**Re: DART+ West Railway Order - Dublin City to Maynooth and M3 Parkway**

We are writing to submit our observations on the DART+ West Electrified Railway Order 2022 (Case reference: NA29S.314232 - <https://www.pleanala.ie/en-ie/case/314232>).

In particular we would like to raise our concerns with the proposals for the development for Leixlip Confey Station, and the associated works at Cope Bridge and on the green space Glendale Estate, Leixlip, Co. Kildare.

Drawing Number | Project | Originator | Discipline | Location | Type | Role | Number | Phase
MAY MDC STR RS12 DR C 0003 D

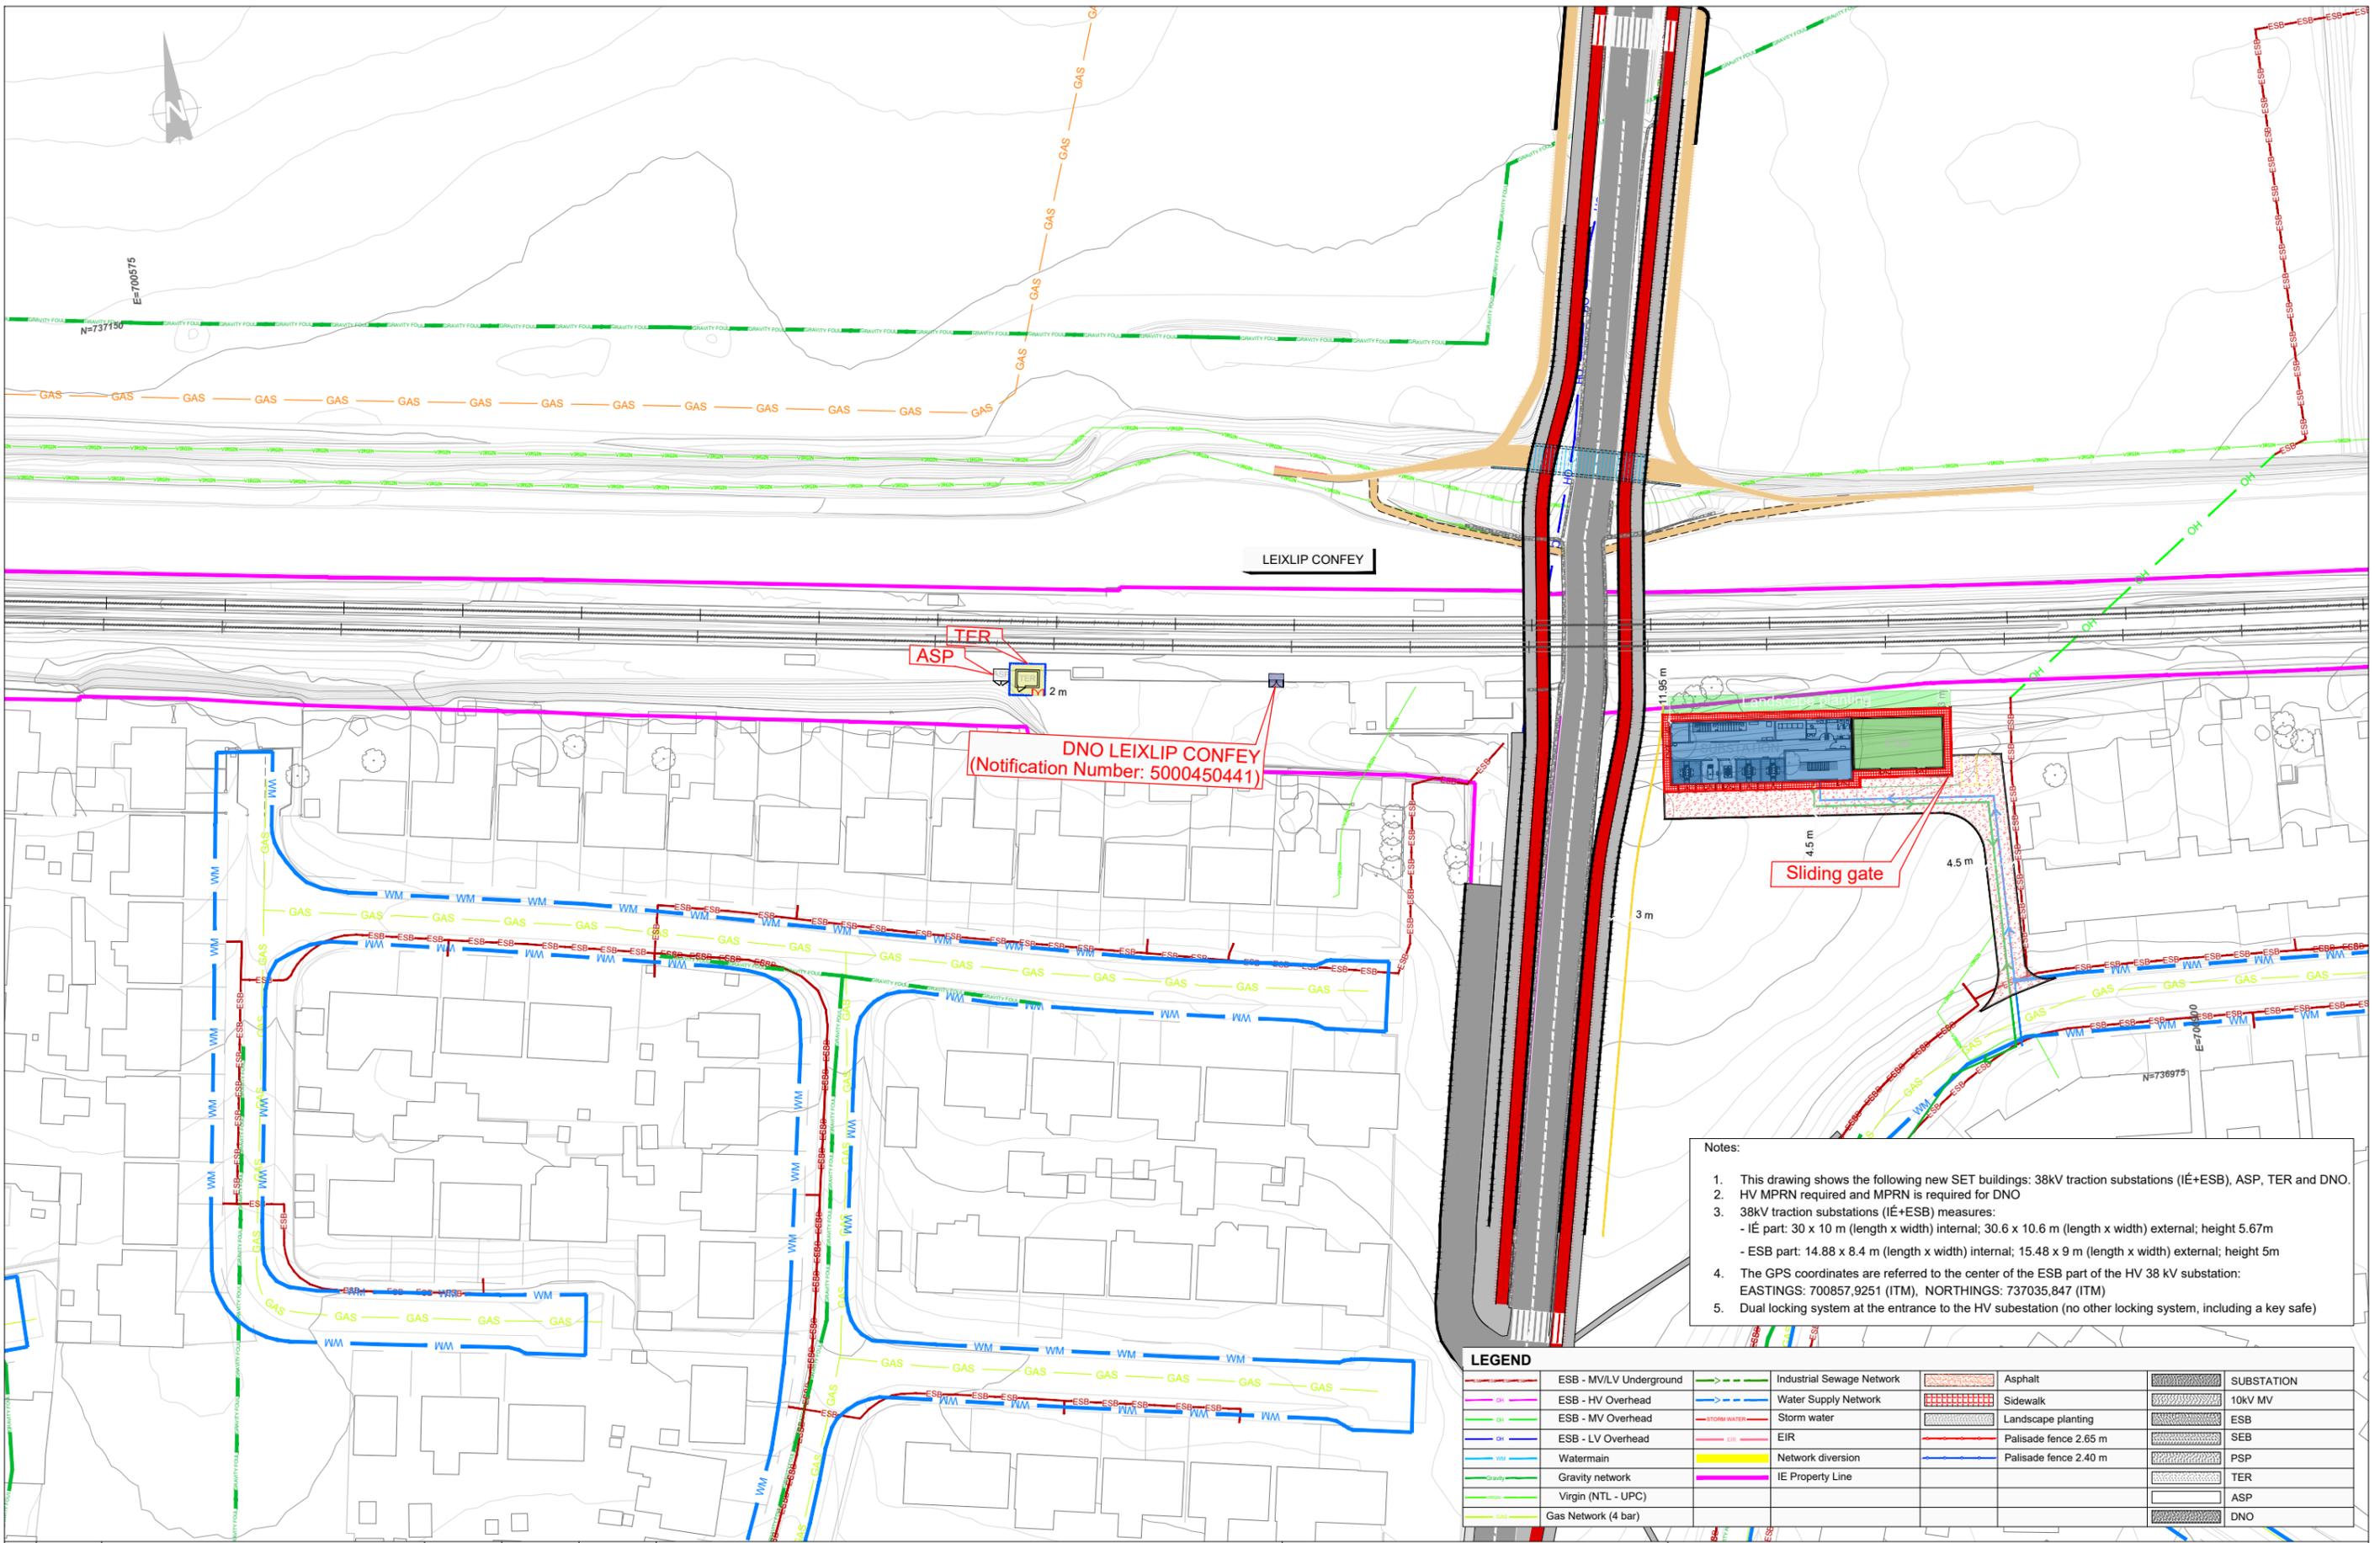
The proposed east footbridge is over 4m in width. It is proposed to build it over the greenspace at Glendale Estate. However rather than constructing it in the traditional manner on pillars with free area underneath it, the proposal includes a large embankment and retaining wall. The area of this embankment is unclear, and from Drawing MAY MDC SET RS12 DR Z 0003 D, we had assumed that the yellow line with '3m' beside it was showing the size of the embankment, resulting in over 7m of greenspace removed along the full length of the existing wall, as highlighted below:

However, we believe that this is in fact not the case and that the embankment would take up considerably further space based on Drawing MAY MDC STR RS12 DR C 0003 D, which shows the green embankment area far wider at times than the footbridge and therefore wider than 4m. In fact, it appears that 3m is in fact the minimum and that the width of the embankment could be over 1.5 times the width of the footbridge at its widest. This would therefore result in the greenspace being reduced in width by over 10m at times.

We believe that full transparency on this point has not been provided, thereby making it difficult for us and others as residents to fully assess the actual impact in terms of permanent loss of our recreational amenity.

Moreover, we can see no reason for the inclusion of the embankment which only serves to further increase the amount of greenspace lost. Also, it is unclear as to who would maintain the embankment given that it is us as residents who have been maintaining the green area for 45 years.

Furthermore, the proposed construction of the east footbridge includes the removal of mature trees. We see no effort being made to design a bridge in such a way as to maintain the beautiful mature trees and believe that this could be achieved with a more innovative design, and/or also with the reduction in the bridge's size to accommodate either foot or cyclist traffic only, as suggested above. The design as it is, is incongruous with the area.
